CITY OF PORTLAND, MAINE
DEVELOPMENT REVIEW APPLICATION
PLANNING DEPARTMENT PROCESSING FORM

2004-0137
Application I. D. Number
6/29/2004
Application Date
Boathouse/Guesthouse
Project Name/Description

July 13, 2004

RE: 328 Island Avenue, P.I. – 087-R-002 – IR-2 Zone – Shoreland Zoning – Floodplain

BOUNDARY SURVEY PLAN
334 ISLAND AVE PEAKS ISLAND, MAINE

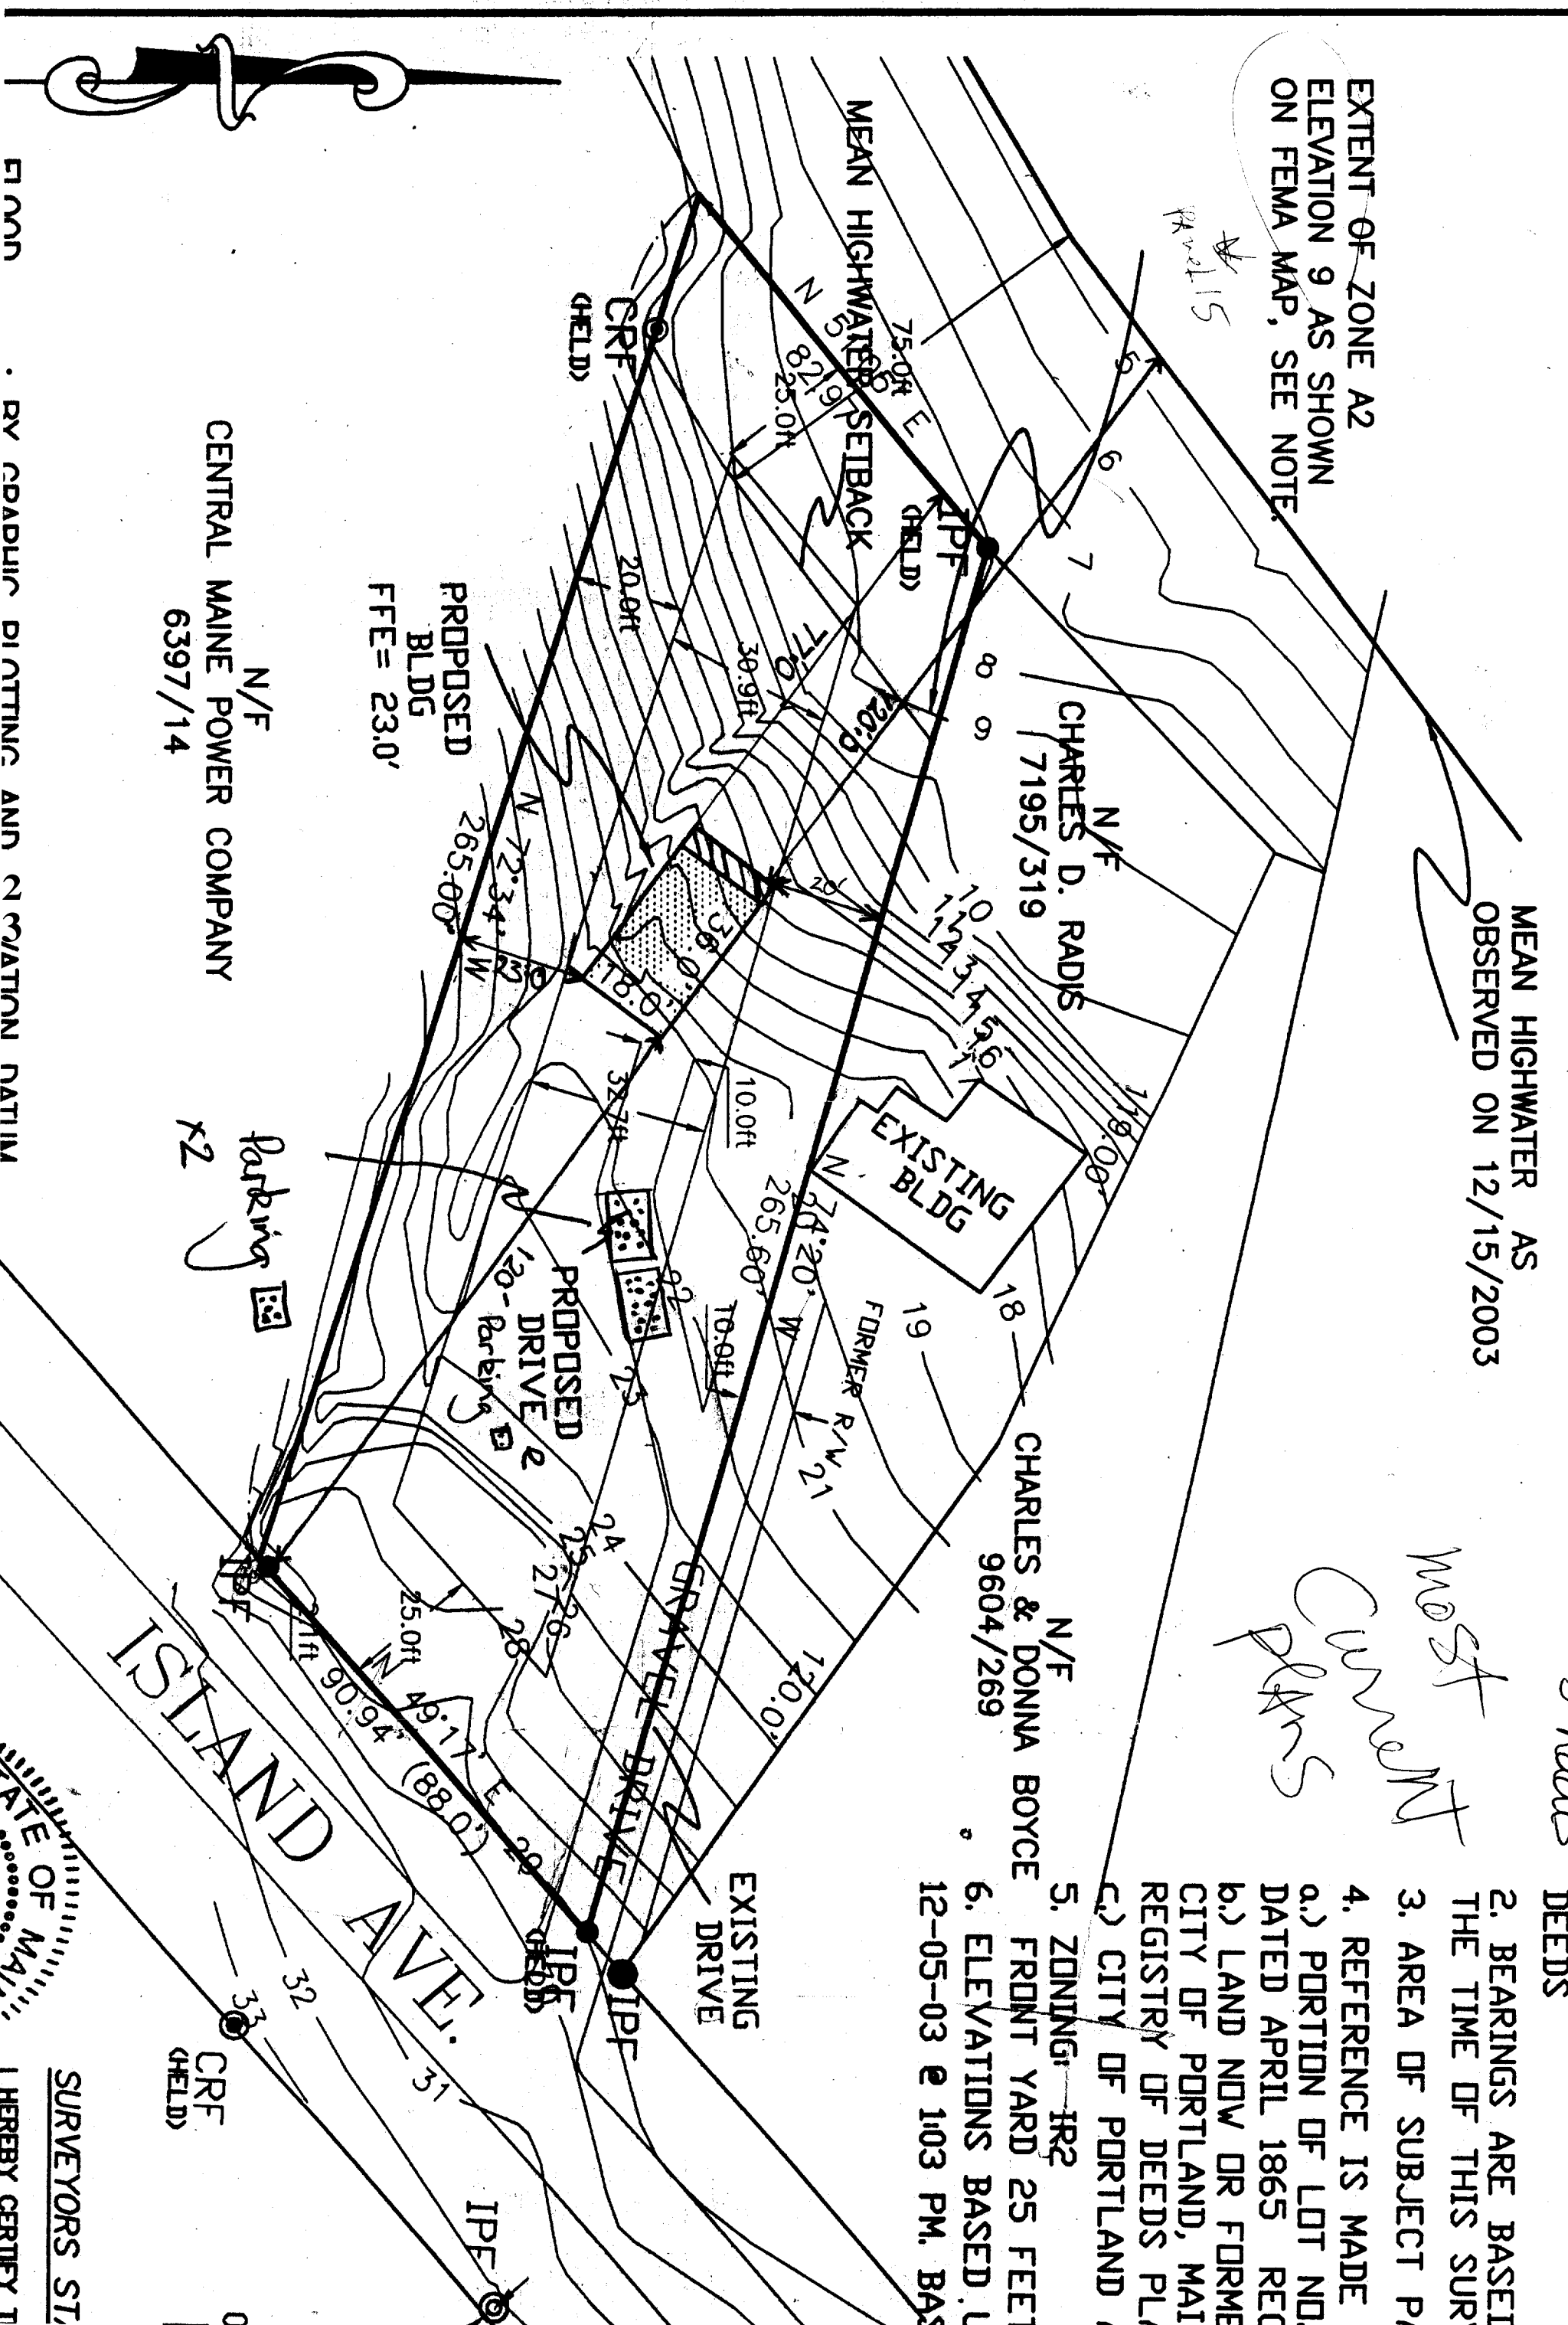
This property is located within the Shoreland Zone area. Section 14-449 of the Zoning Ordinance requires structures to be setback a minimum of 75 feet from the high water mark, instead of the 45 feet from the mean high water mark that you have shown on your plans.

This property is located with the Flood plain area A2 with a given elevation of 9 as denoted on FEMA panel 15. 14-450.8 requires the lowest floor elevation to be a minimum of two feet above the given elevation of 9 feet. The lowest floor elevation by definition would be your boat storage area. Your plans are deficient in denoting what the lowest floor elevation is using N.G.V.D. It is your responsibility to verify and supply that information with your application.

Section 14-332 requires all new dwelling units to show two off-site parking spaces. None are shown on your submitted plans.

11'8" above MHT
(mean high tide)

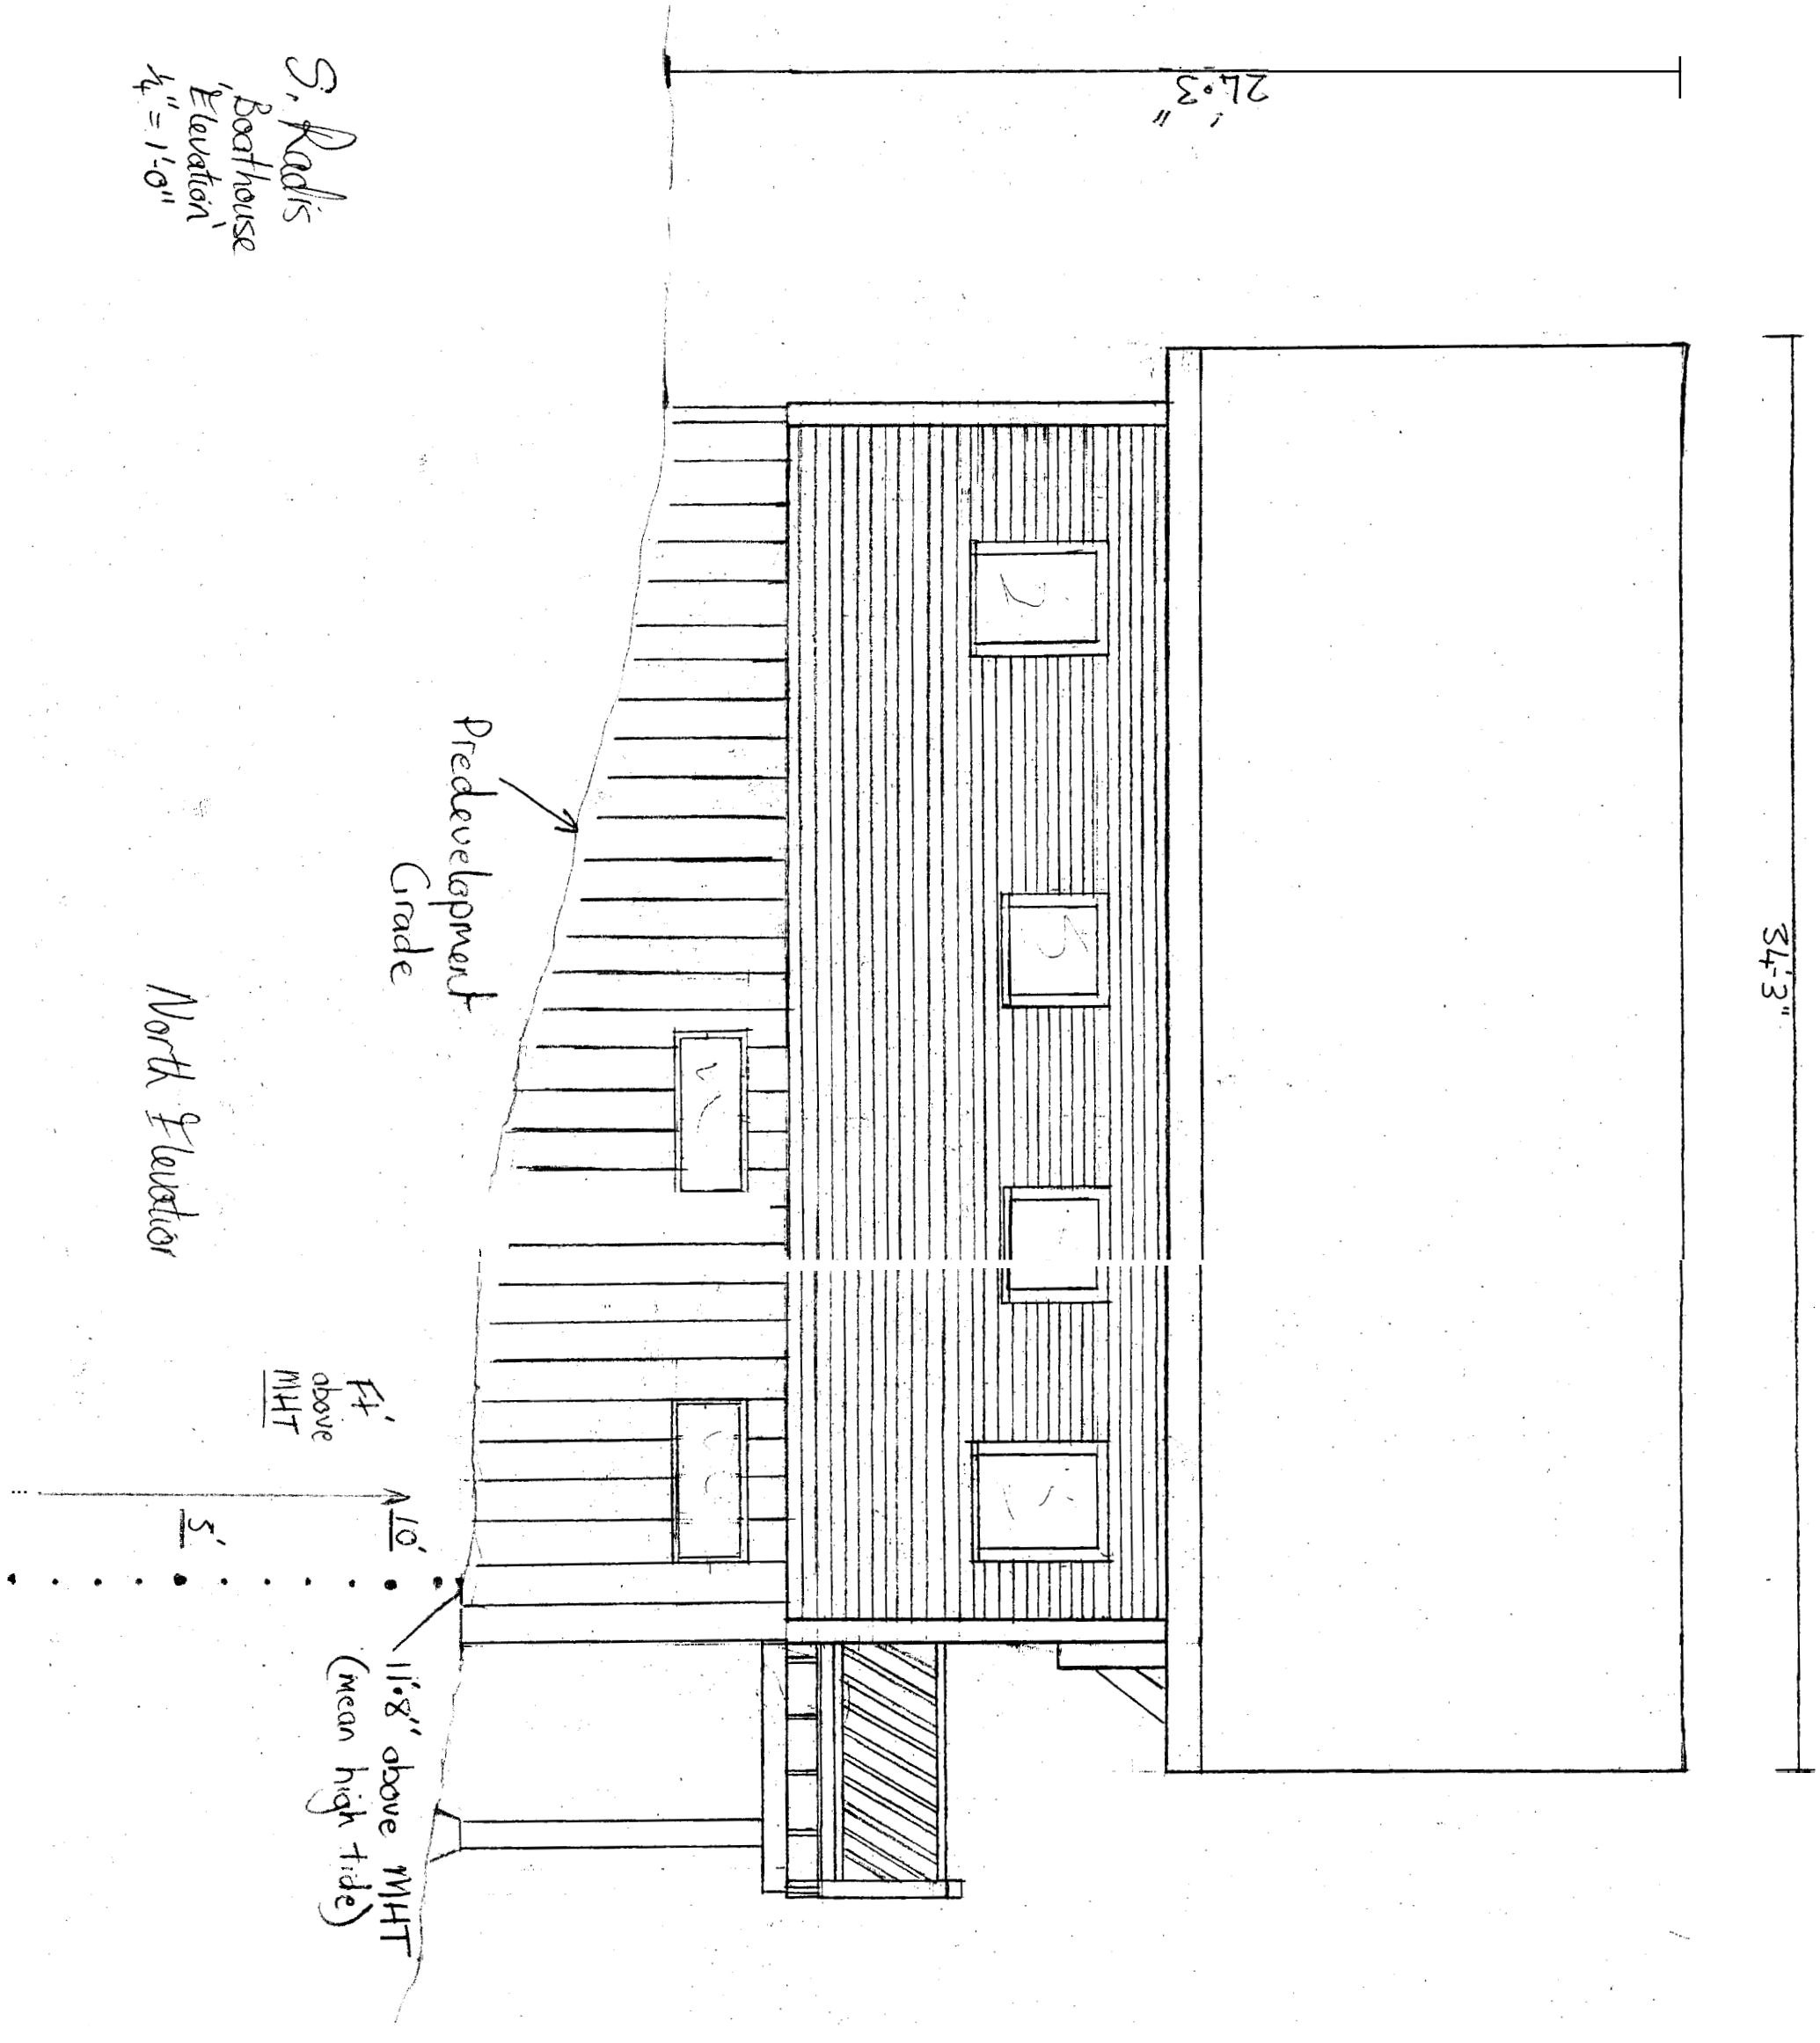
Section 14- 145.11 requires the maximum building height for a principal building to be no more than 35 feet from pre-development grade. This office has not been provided with any such

information. This office will require all predevelopment grades around the proposed house prior to any approvals.
